Application no: H17/0006/99

Description: Alterations & extensions &
conversion of outbuildings
to form single dwelling.

Location: Coney Garth Lane
Surfleet
Spalding
Lincolnshire

Amendment: Alterations to chimney stack, alter window to lounge/
landing, amend roof to entrance hall. Dwg. No. 99/01/01A

FIRST FLOOR PLAN LAYOUT

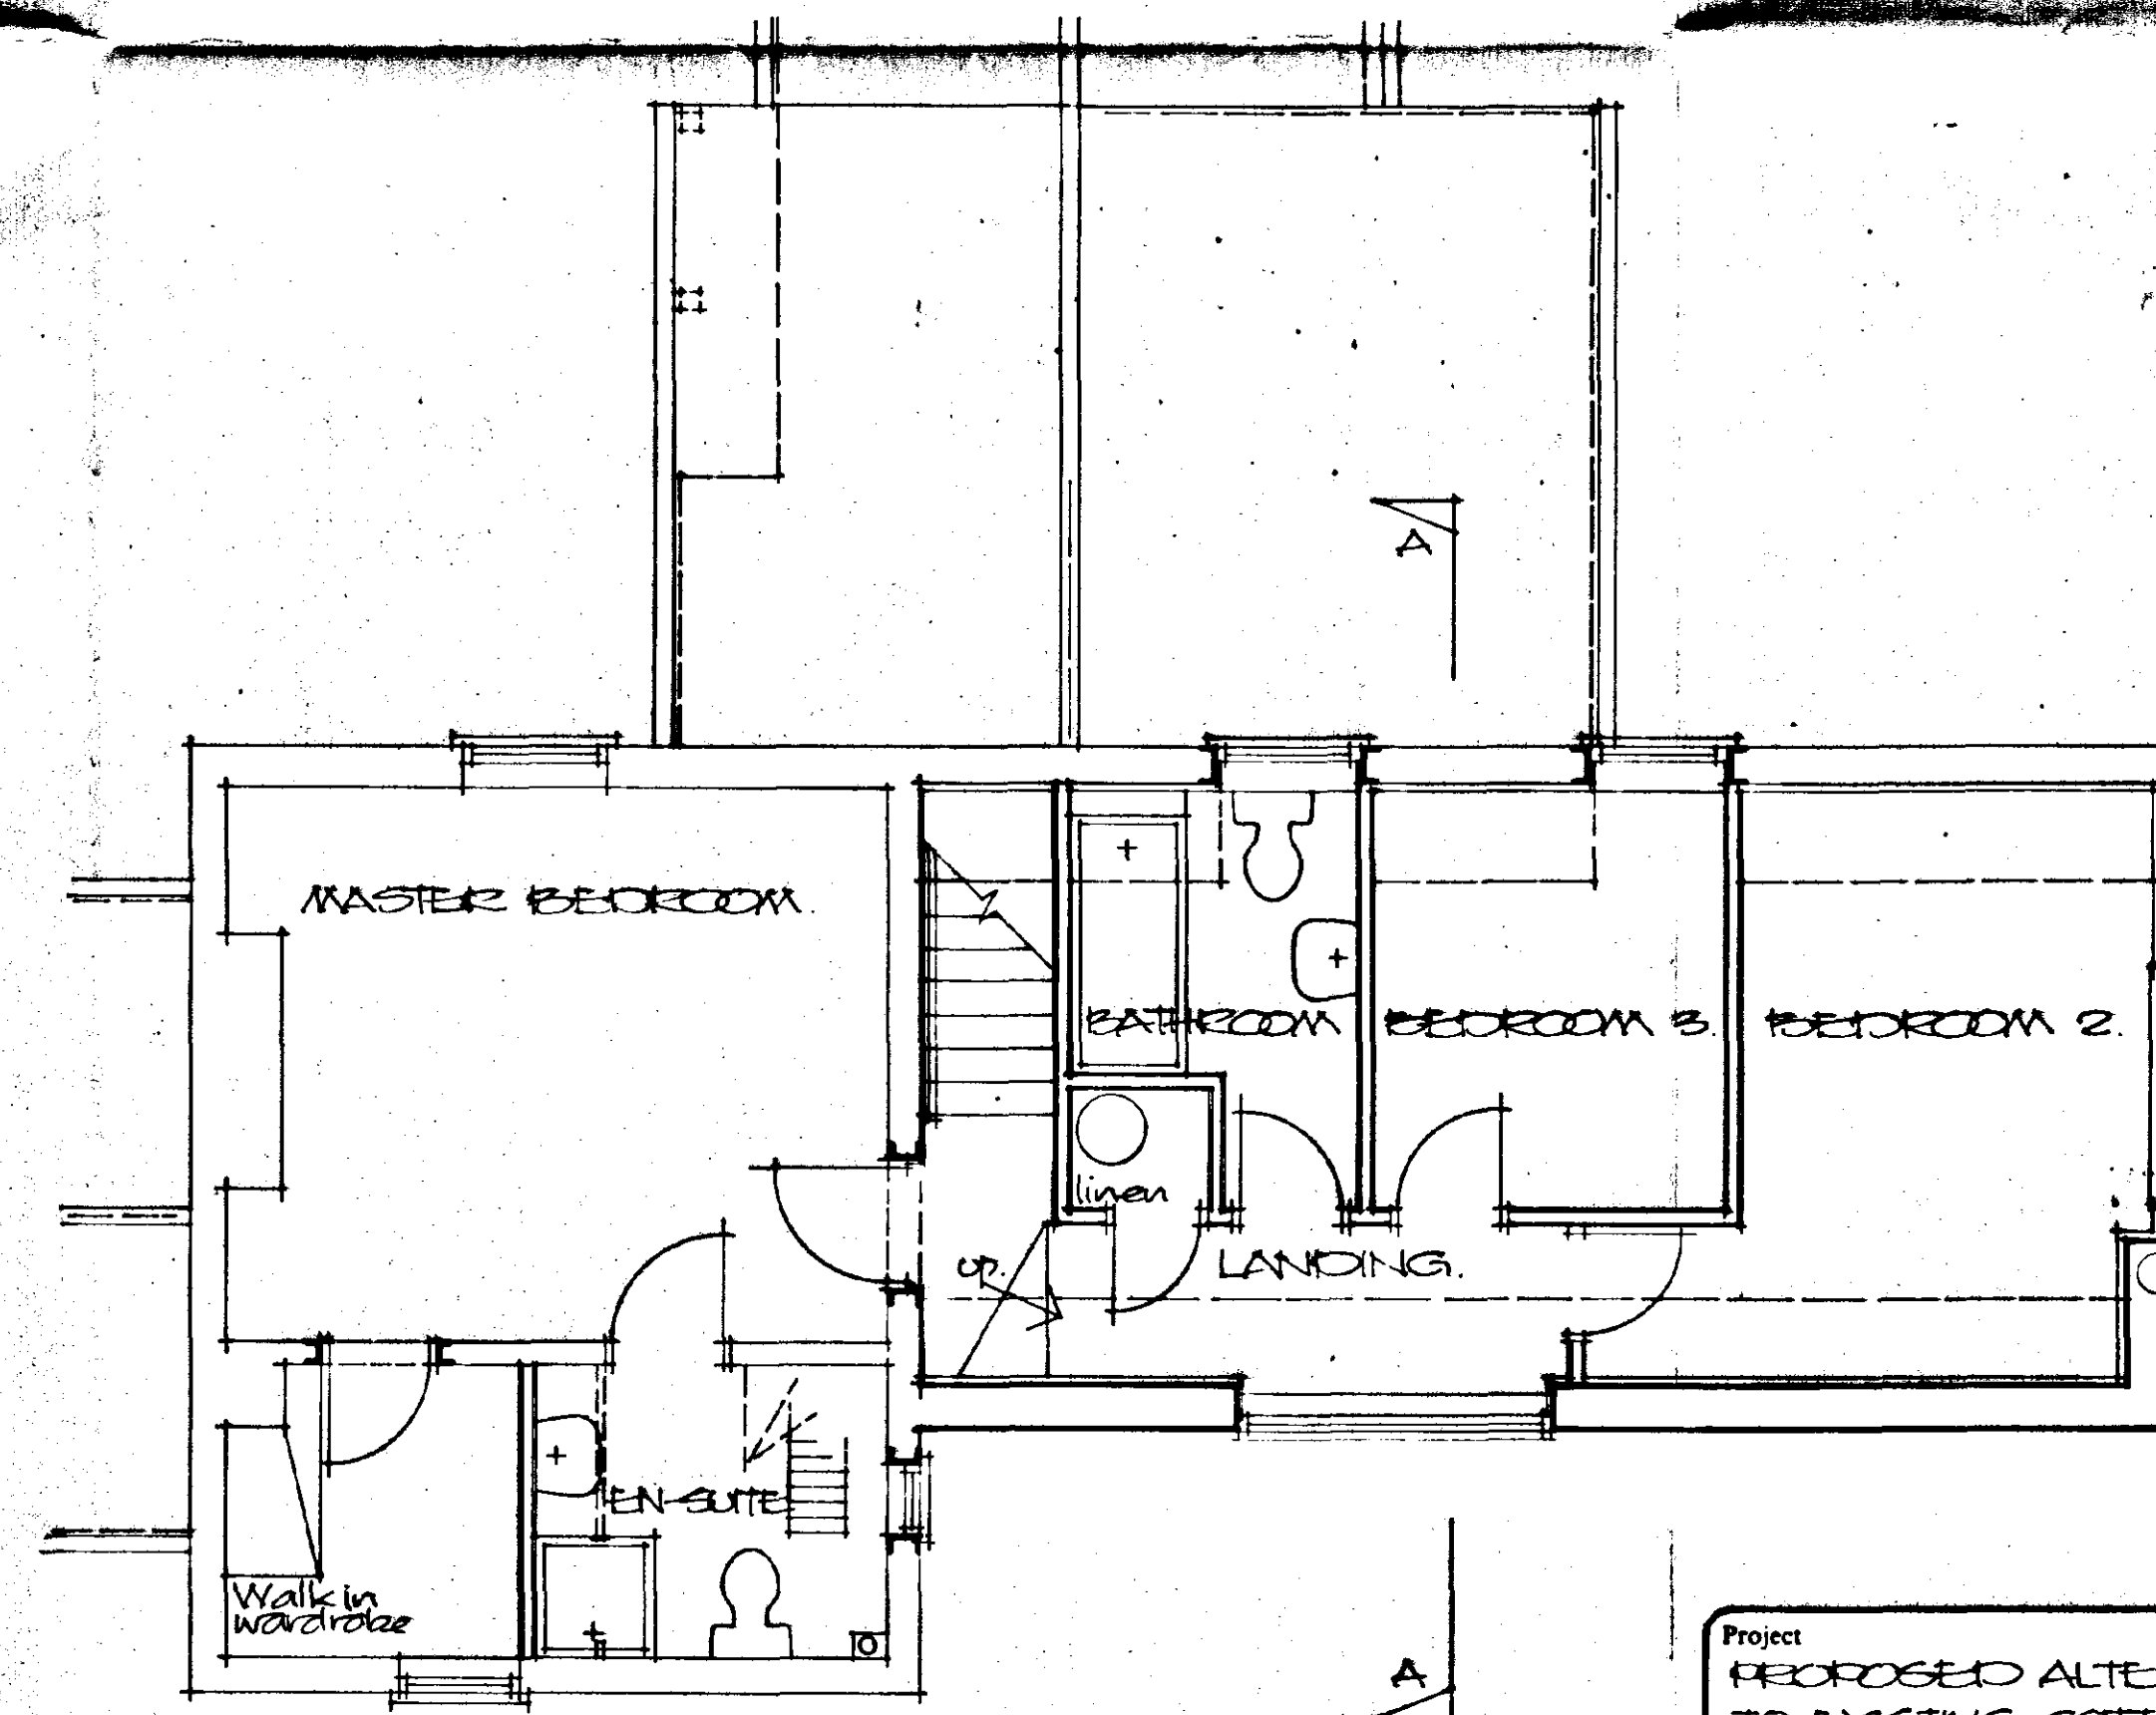
1. CHIMNEY STACK TO LOUNGE ALTERED.
2. WINDOW TO LOUNGE / LANDING ALTERED.
3. DOOR TO ENTRANCE HALL ALTERED.
AND TYPE OF DOOR TO OUTSIDE.
